RESPONSE TO REQUEST FOR FURTHER INFORMATION - 104-116 REGENT STREET, REDFERN

This letter has been prepared by Urbis on behalf of Wee Hur and relates to State Significant Development Application (**SSDA**) at 104-116 Regent Street, Redfern (**SSD-12618001**).

This letter responds to a Request for Information (**RFI**) issued by the Department of Planning and Environment (**DPE**) on 15 July 2022. DPE requested responses to additional submission by City of Sydney, Sydney Metro and one public submission following their review of the Response to Submissions (**RtS**) report submitted by Wee Hur on 15 June 2022.

2.14 WIND DETAILS

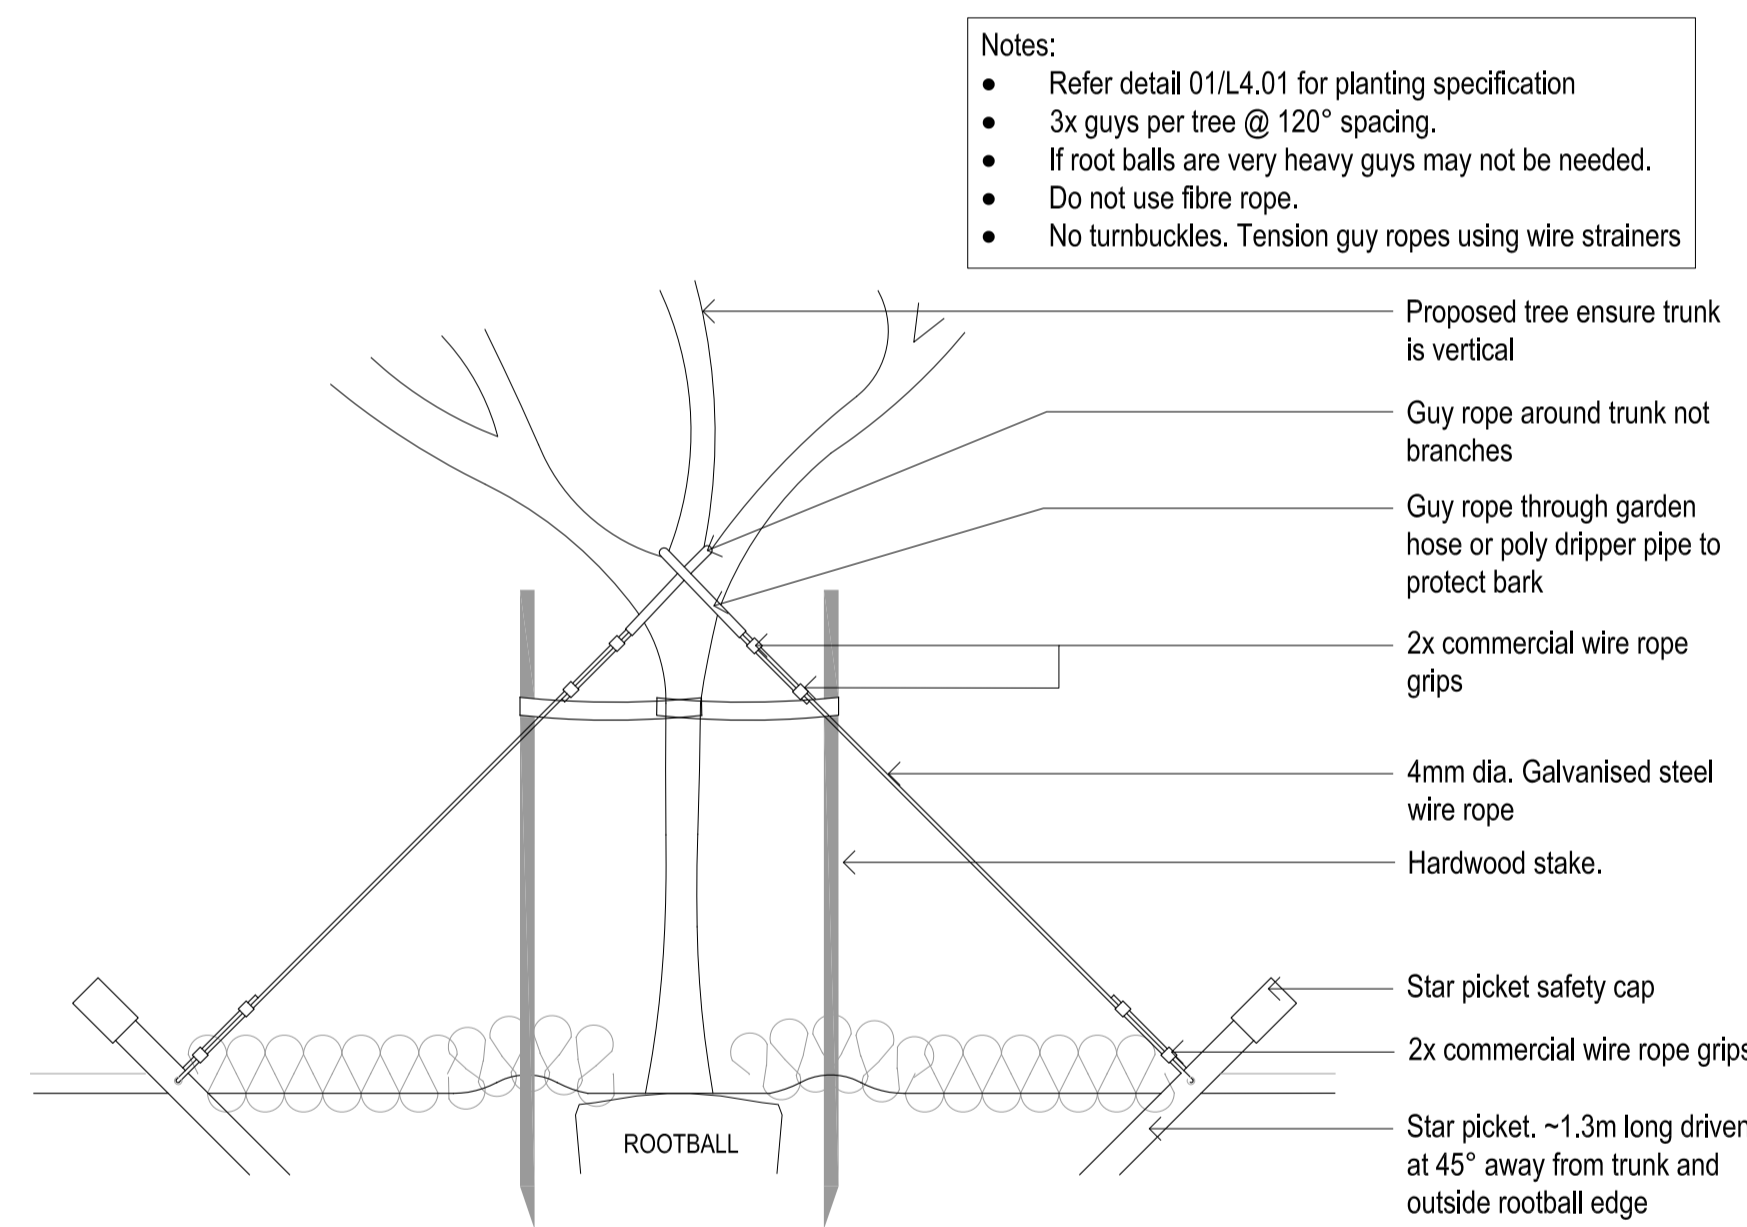
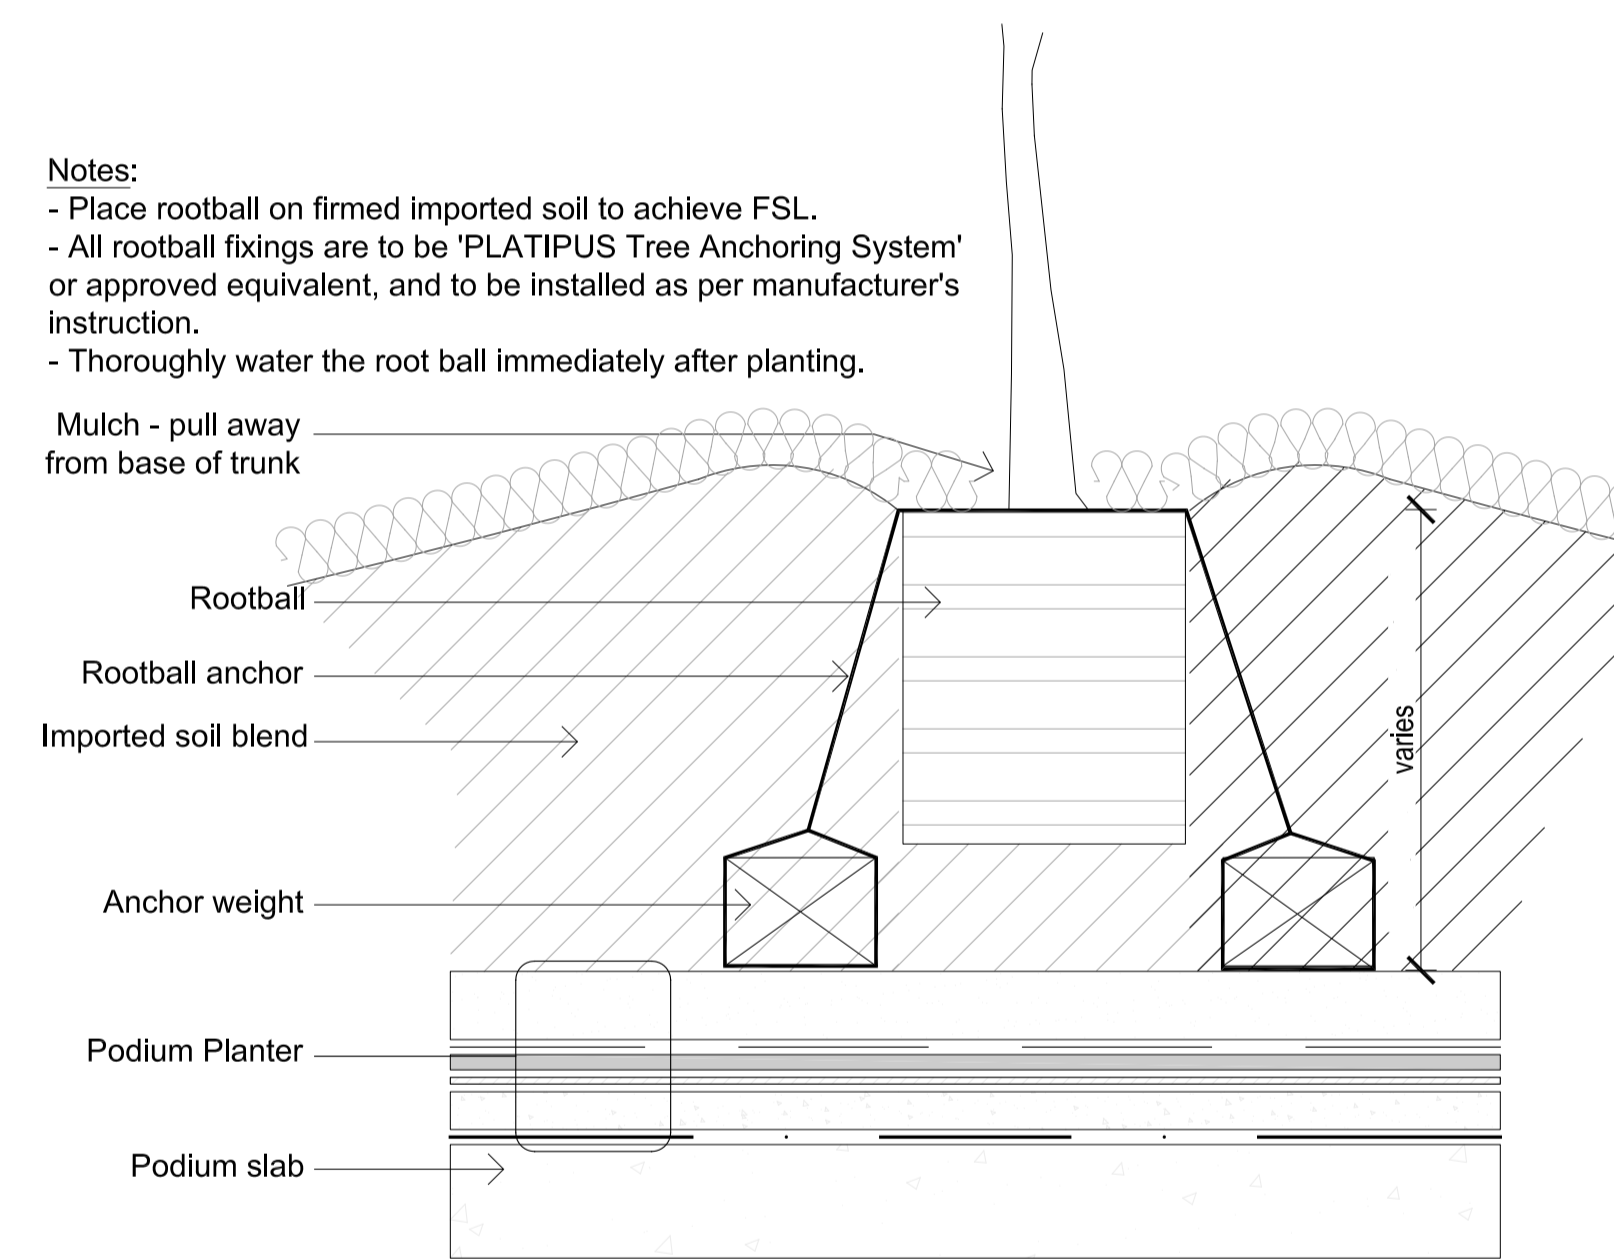
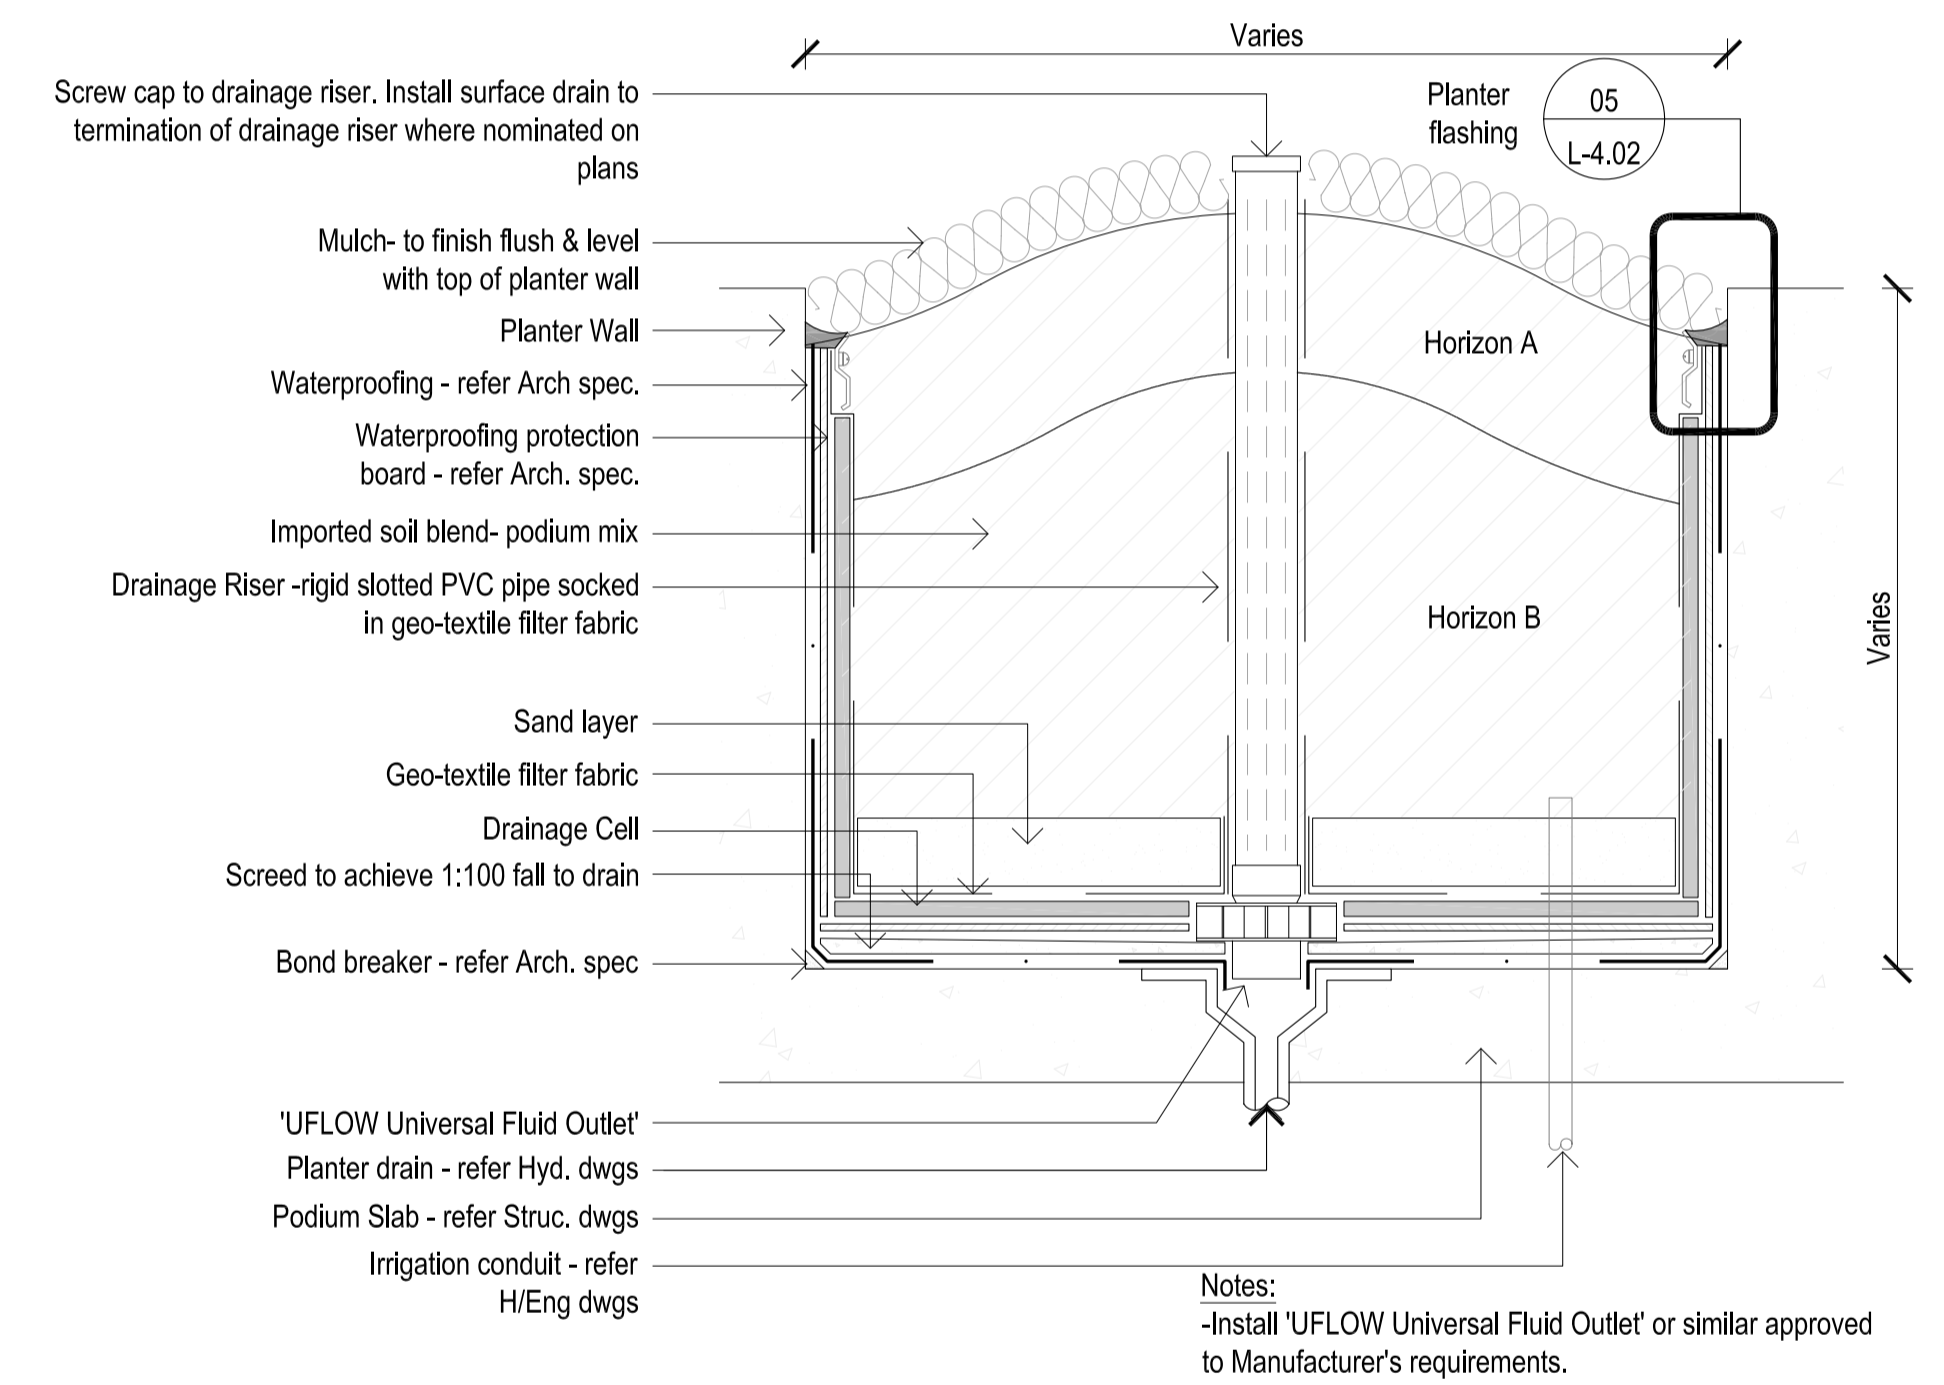
<p>b. Wind Impacts</p> <p>The executive summary of the Updated Environmental Wind Assessment Report, prepared by SLR, outlines the recommendations for wind amelioration. These should be requested to be reflected in the architectural and landscape packages, including the detailed recommendations to the Level 2 and 16 outdoor areas, prior to the determination to ensure these elements are well designed and integrated into the development.</p>	<p>The Wind report (June 2022) by SLR Consulting recommended the following treatments:</p> <ul style="list-style-type: none"> Retention of the proposed vertical façade screening along the perimeter of the development (from level 2 slab up to level 4 slab). Retention of the proposed tree planting on the Level 2 communal area, Level 4 outdoor area and Level 16 communal area.

Comment	Response
<p>Additionally, locations 4 and 5 within the through-site link are indicated as seating areas on the landscape plan. Therefore, further landscape mitigation measures are recommended to be implemented to achieve the required 4m/s wind criteria for sitting prescribed by Sydney DCP 2012.</p>	<ul style="list-style-type: none"> ▪ The proposed landscaping should be evergreen. ▪ Localised horizontal protection (eg pergola, shade-cloth, umbrellas, etc) to protect any elevated terrace areas intended to be used for outdoor dining. <p>The amended Architectural Plans (Appendix D) and Landscape Plans (Appendix E) show the retention of extensive planting across the outdoor terraces and localised horizontal protection.</p> <p>The through-site-link is not within the subject site boundary. A modification application is currently being prepared by Wee Hur for the adjoining proposal at 13-23 Gibbons Street to address these recommendations.</p>
